D/2017/349/A (SSD8105-Mod-1) and D/2024/854 (SSD64090972)

As an owner and resident of lots in Strata Plan 51487, known as Victoria Tower, 197 Castlereagh Street, Sydney, I object to the State Significant Modification application D/2017/349/A, and I also object to detailed SSDA -D/2024/854, both lodged on behalf of Charter Hall Holdings Pty Ltd, the Applicant, which are being assessed concurrently, in respect of 201-217 Elizabeth Street, Sydney.

REDUCTION CALCULATION METHOD 2
WITHOUT CONTEXT

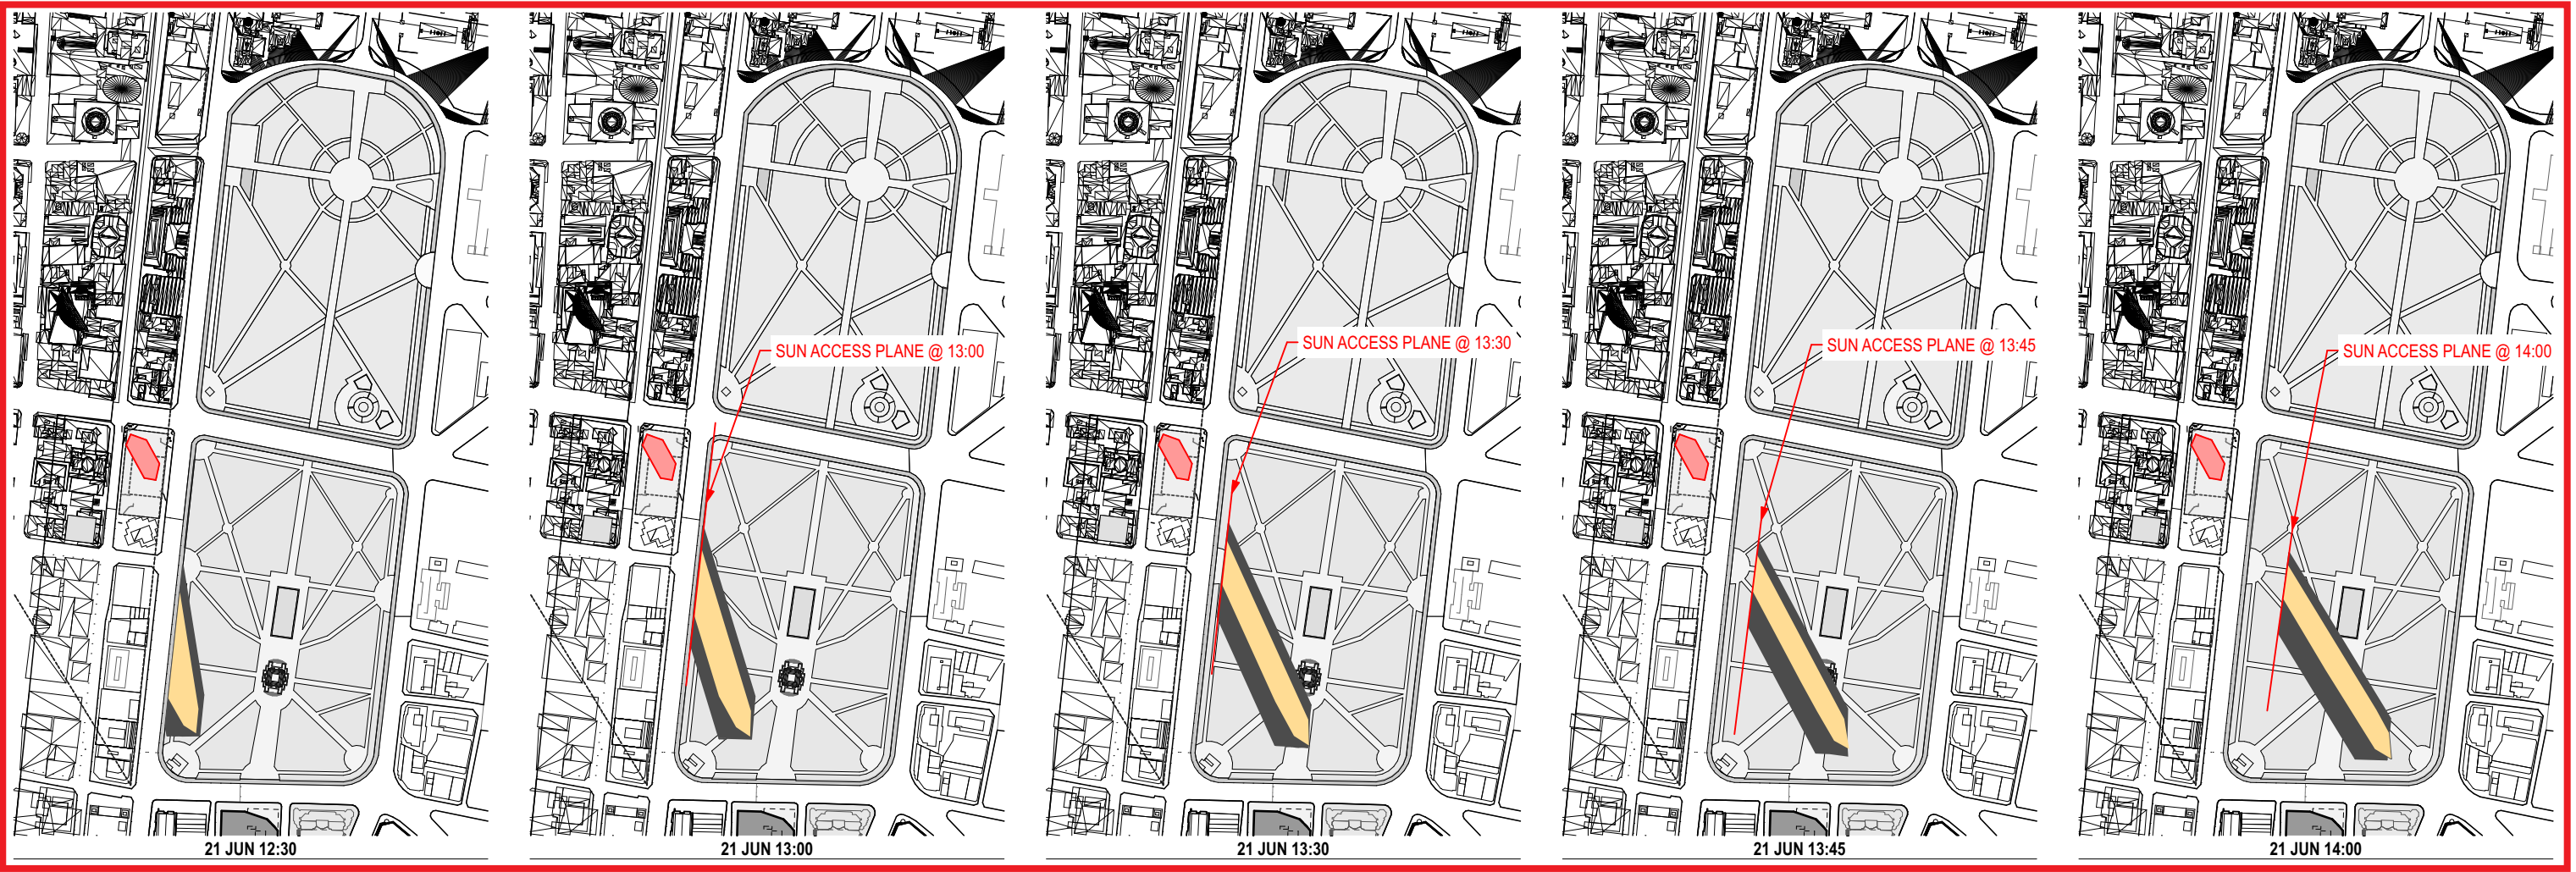
The Applicant's approach to the 50% overshadowing reduction, uses a 'cumulative' calculation, is flawed and inconsistent with the ordinary interpretation of the expression- ...“between (certain hours)”. Words should be given their ordinary and common meaning. Consequently, the requirement for at least 50% reduction in overshadowing commencing at 12:00 on the relevant day and continuing uninterrupted until 14:00 must mean that there is a continuous reduction for the whole period. The Proponent's own shadow diagrams and calculations show non-compliance at least between 12:30 and 13:00.

The Applicant's own shadow diagrams, Figure 55, which are reproduced below, clearly indicates significant overshadowing of Hyde Park in breach of the requirements of the Hyde Park sun access plane from 12 noon to 2 PM on 21 June (shown green). In addition, the diagrams also show new “Additional” overshadowing (shown blue) which breaches the prohibition.

The table of calculations, Table 21, establishes that the proposal would create overshadowing during the 12.00-2.00 period of 13086m², or 1.3086 hectares, during the busiest part of the day for users of the Park! The overshadowing at 13.00 to 13.30 is shown as 4,031m², a greater area than the entire site at 201-217 Castlereagh Street which is 3901m².
